**Consultation Response from KC,
Highways Development Management**
2020/94285 22-26, Wellington Road, Dewsbury, WF13 1HL
Alterations to office building to form 20 flats and associated office space and laundry (Listed Building within a Conservation Area)
**Date
Responded: 24/02/2021**
**Responding Officer: Mark
Berry**
Responding Ref: 15-2NW-3

This application seeks approval to the alterations to convert an existing office building to form 20 one bedroomed flats and associated office space and laundry at 22-26, Wellington Road, Dewsbury.

PROPOSED GROUND FLOOR PLAN

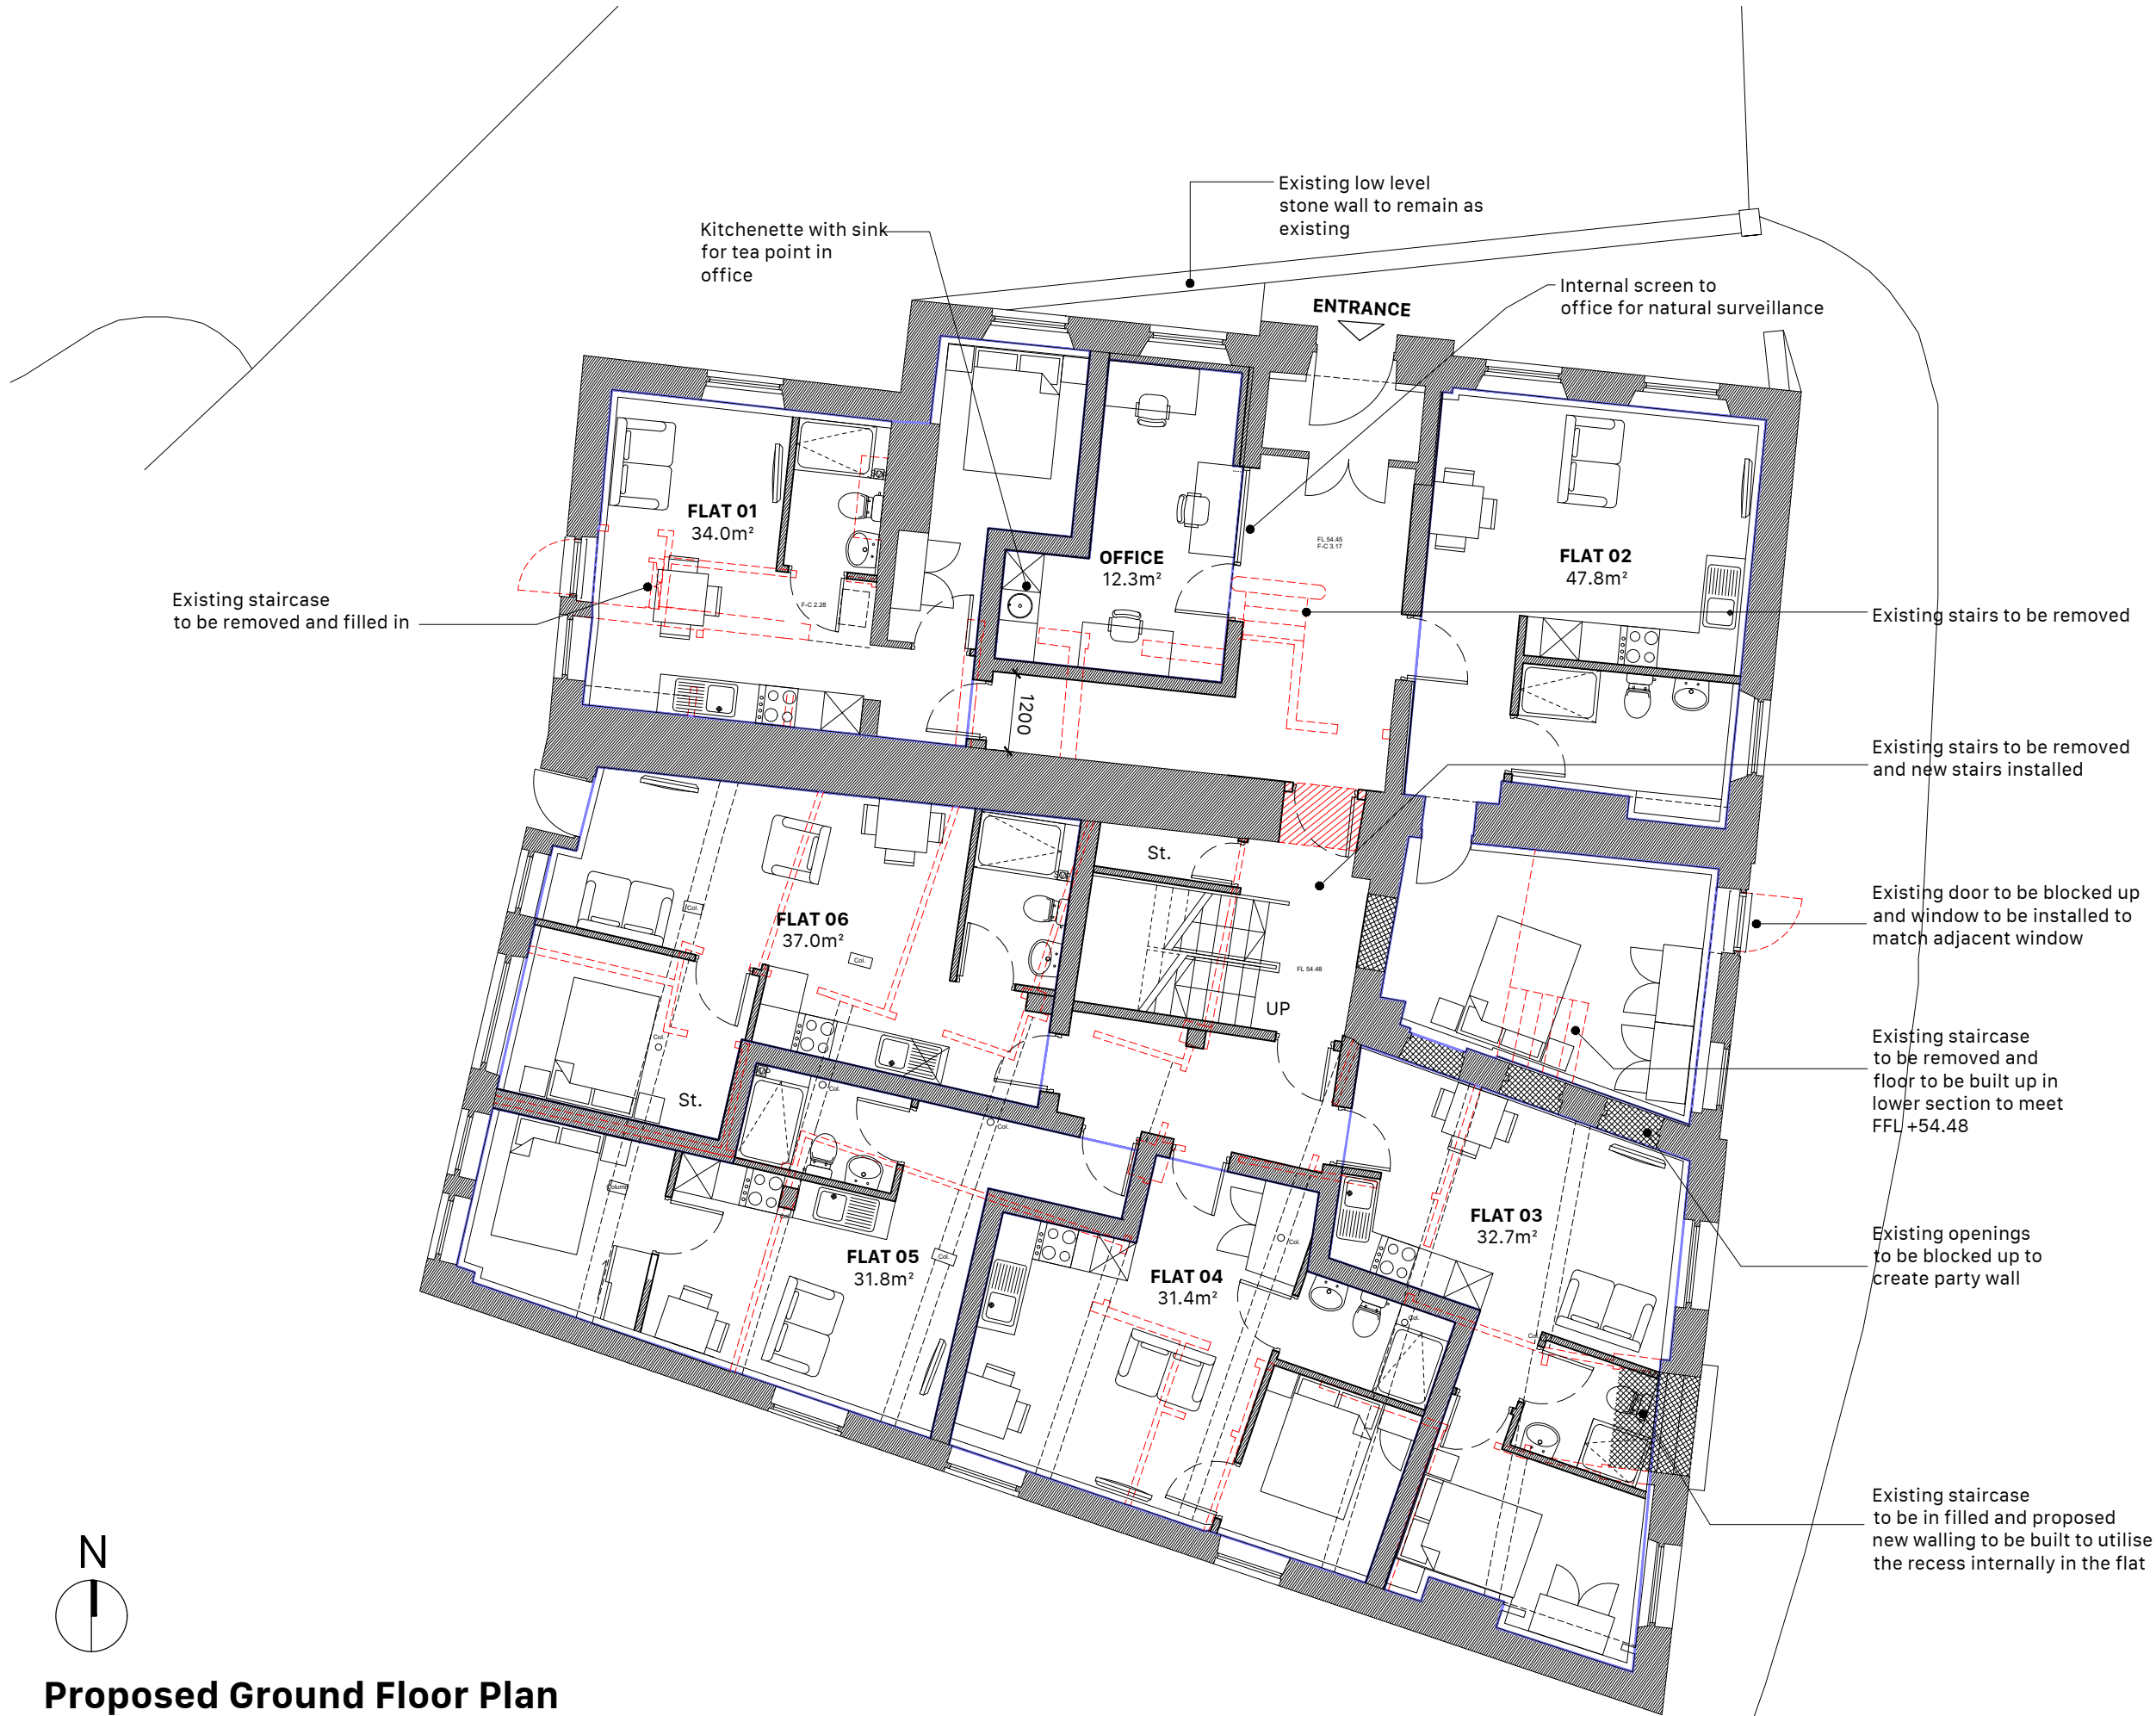
The Design and Access Statement confirms that vehicular and pedestrian access will remain the same as existing. The site entrances from Wellington Street are to be blocked up and only the main front entrance utilised.

No details of the of the proposed servicing arrangements are provided. The comments from Waste Strategy are attached.

The red line boundary includes a small forecourt to the site frontage with access from Wellington Street and Dewsbury Ring Road. No information is provided to explain how this area will be used and no plans are provided to show how this area will be marked out.

No details of any proposed provisions for cycle parking are provided.
